**Appeal by Great Lakes UK Limited
Proposed Great Wolf Lodge, Chesterton**

Appeal Ref: APP/c3105/W/20/3259189

Proof of Evidence

**On matters relating to transport planning and traffic
impacts**

Middleton Stoney 1803047-17C.pdf

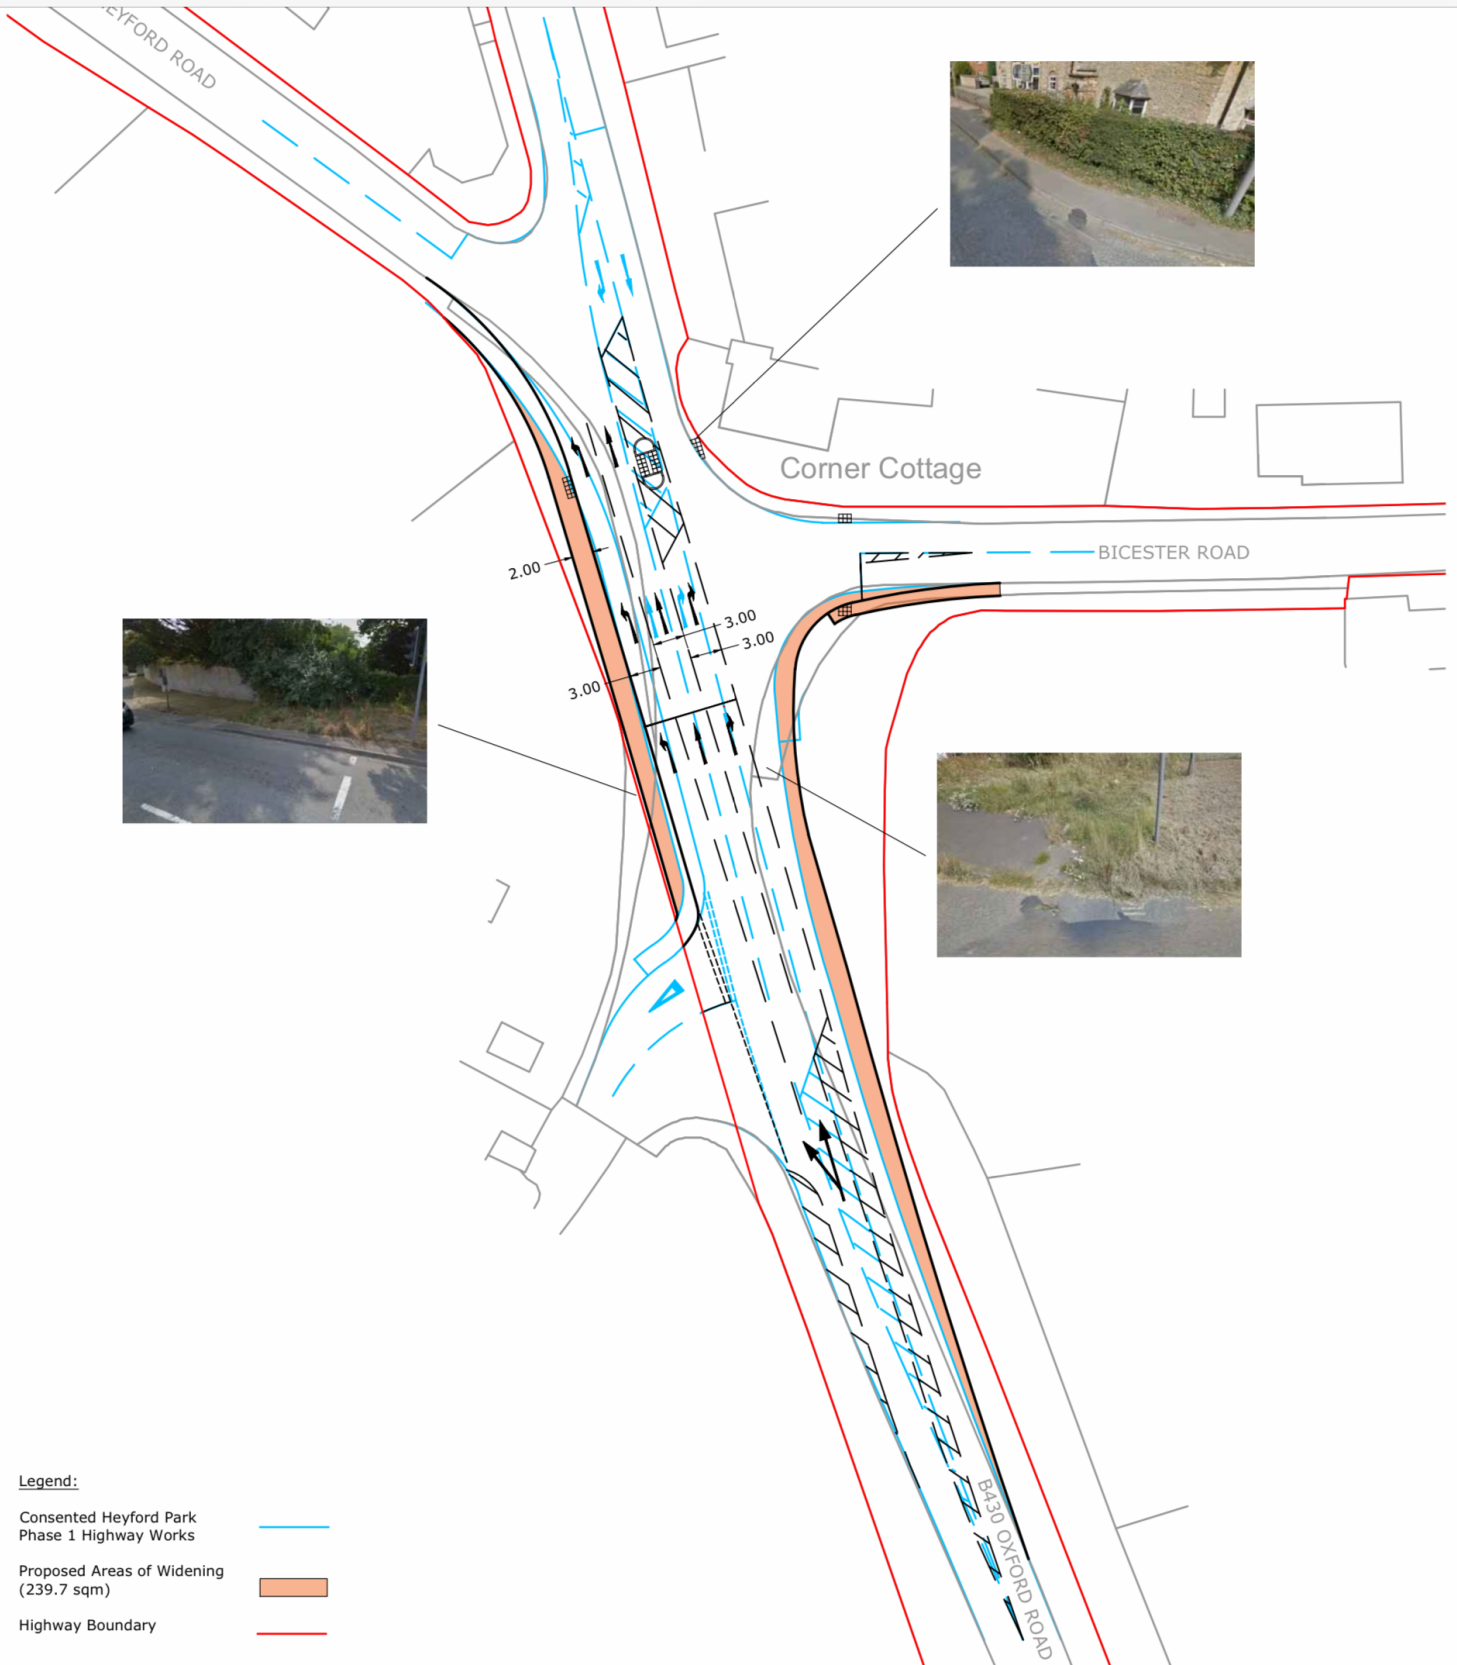
2.3. The submitted scheme of mitigation for the B430 / B4030 Middleton Stoney junction does not meet design standards, does not properly consider other road users and introduces unacceptable road safety issues which are unacceptable to OCC and contrary to NPPF Para 109.

19. 3rd March 2020: (email Response 2) OCC provided a response to The Appellant setting out concerns relating to Mitigation drawing 1803047-17
20. 3rd March 2020: (email Response 3) Motion contacted OCC to note OCC's feedback that the junction proposals were 'undeliverable' and advising that an alternative drawing should be prepared

23. 10th March 2020: (email Response 5) OCC submitted feedback to the Appellant in relation to drawing 1803047-17 Rev A. The email set out a detailed breakdown of concerns and requested that Stage 1 and Stage 2 Road Safety Audits were undertaken of the proposed junction upgrade.
